ST. MARGARETS COTTAGE
1 CHURCH ROAD
ANGMERING
BN16 4JP
W. SUSSEX

Your REF A/63/19/PL
SHAFIQUES.

THE EXISTING BUILDING OF
THIS ESTABLISHMENT IS ONLY JUST
EXCEPTABLE TO STREET SCENE AND
MY OBJECTION IS, TO THE PROPOSED
PLAN, TO RAISE THE EXISTING FLAT
ROOF BY 300mm.

PROJECT
SHAFIQUES, THE SQUARE
ARUNDEL ROAD
ANGMERING
WEST SUSSEX
DRAWING TITLE
PROPOSED FLOOR PLAN, ROOF PLAN &
ELEVATIONS

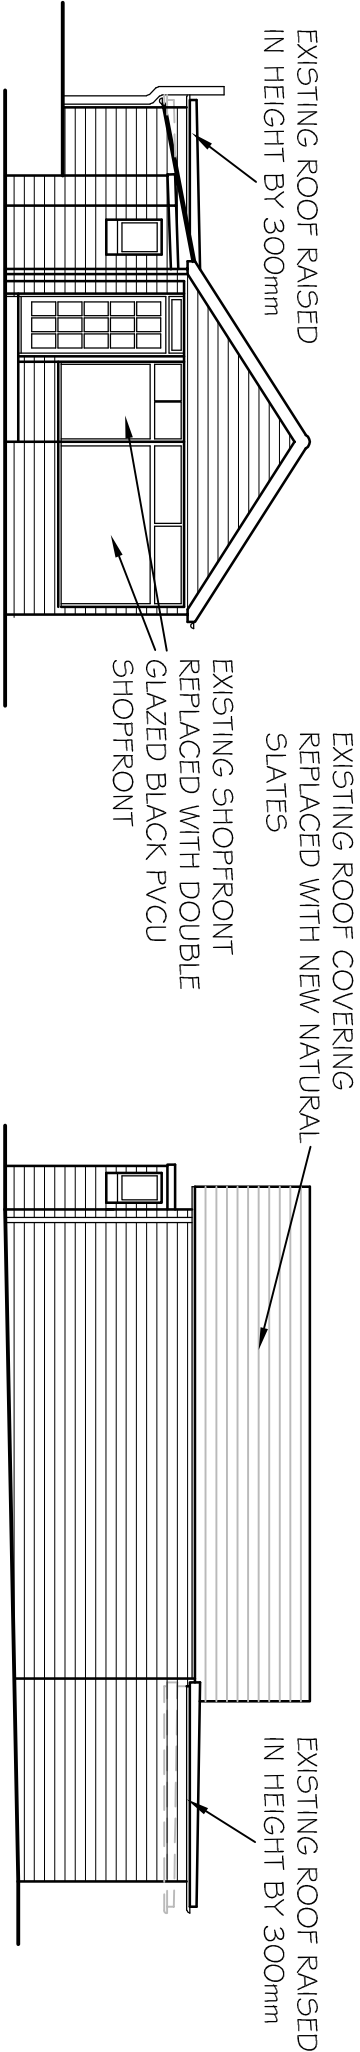
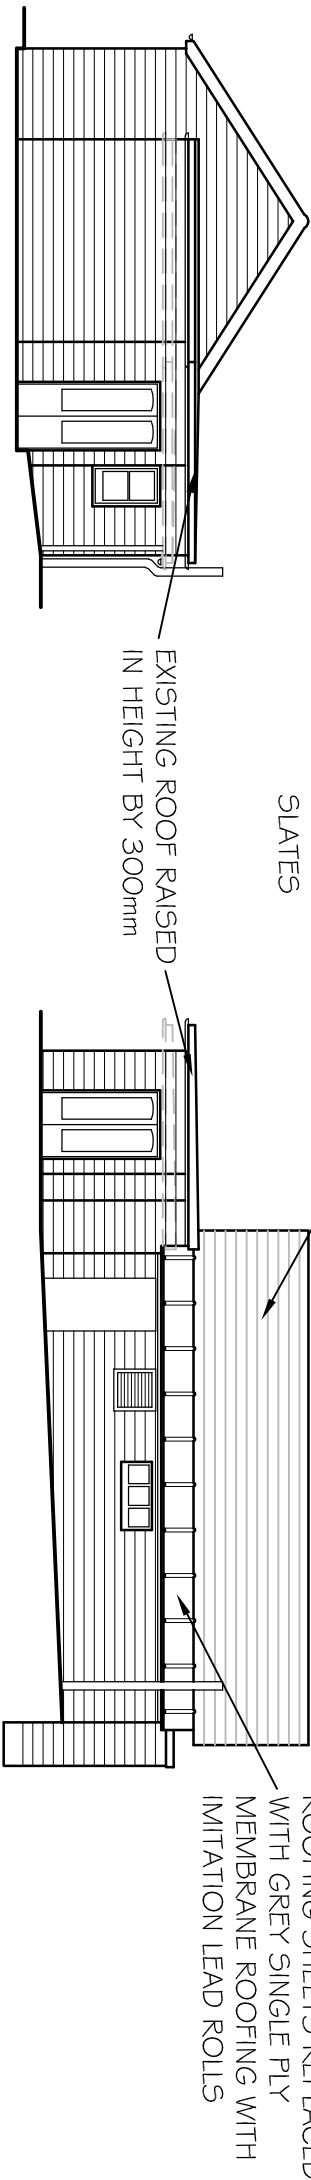
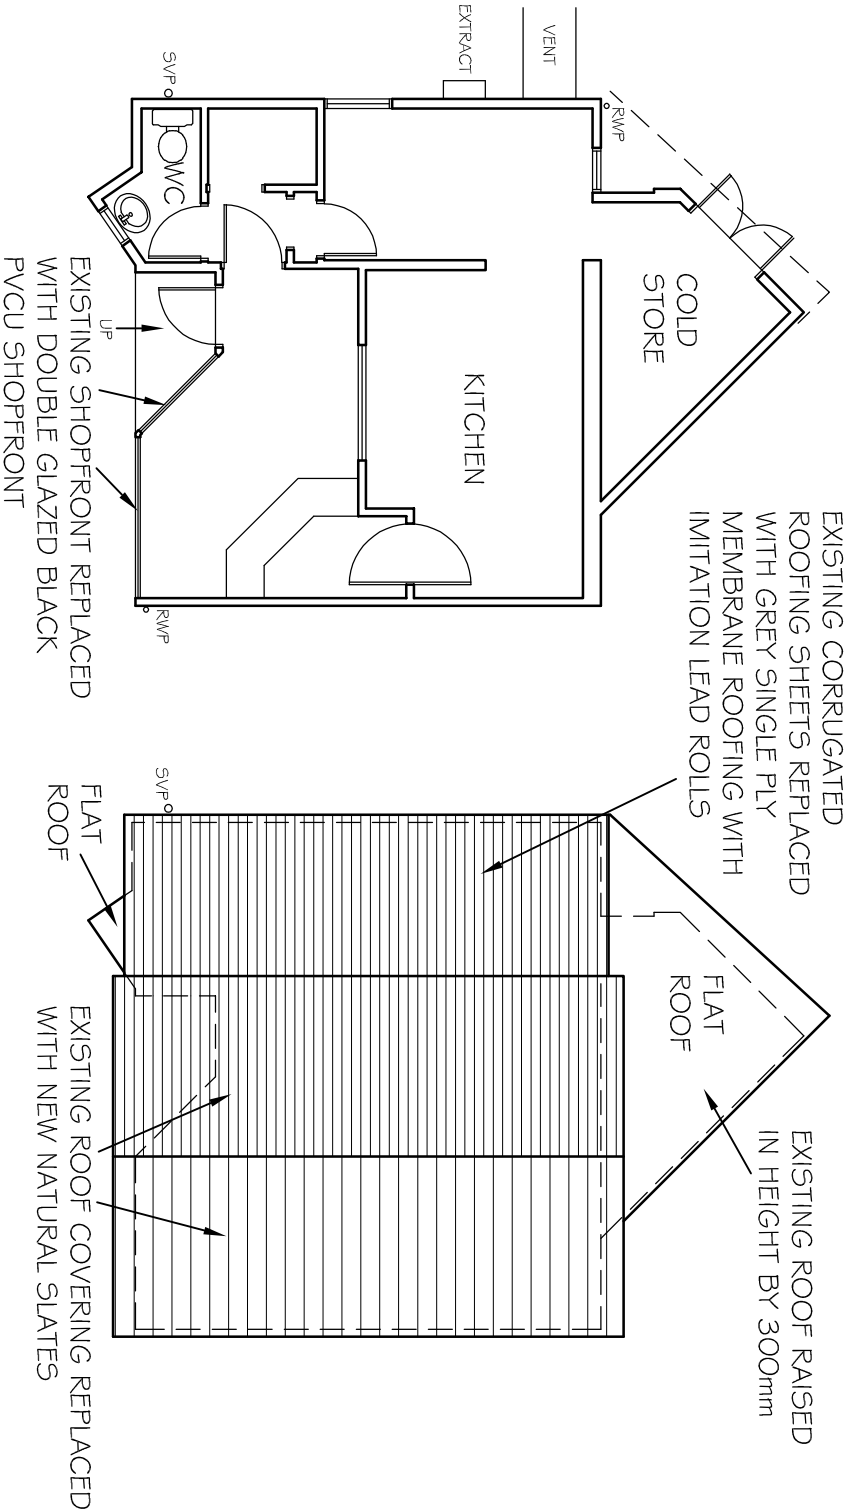
AT THE MOMENT THE ADDED
ON EXTENSION, WHICH I BELIEVE DID
NOT HAVE ORIGINAL PLANNING
PERMISSION, IS OF A HEIGHT TO THE
EXISTING FLINT WALL RUNNING
ALONG CHURCH ROAD.

THE PROPOSED NEW HEIGHT
OF THE FLAT ROOF THEREFORE WOULD
BE IN VIEW ABOVE THIS FLINT WALL
AND NOT IN KEEPING WITH THE
SURROUNDING BUILDINGS IN THIS
CONSERVATION AREA.

I STRONGLY OBJECT TO THIS
PLANNING PROPOSAL ON THE
GROUNDS OF NOT IN KEEPING
WITHIN THE CRITERIA OF THE
CONSERVATION AREA.
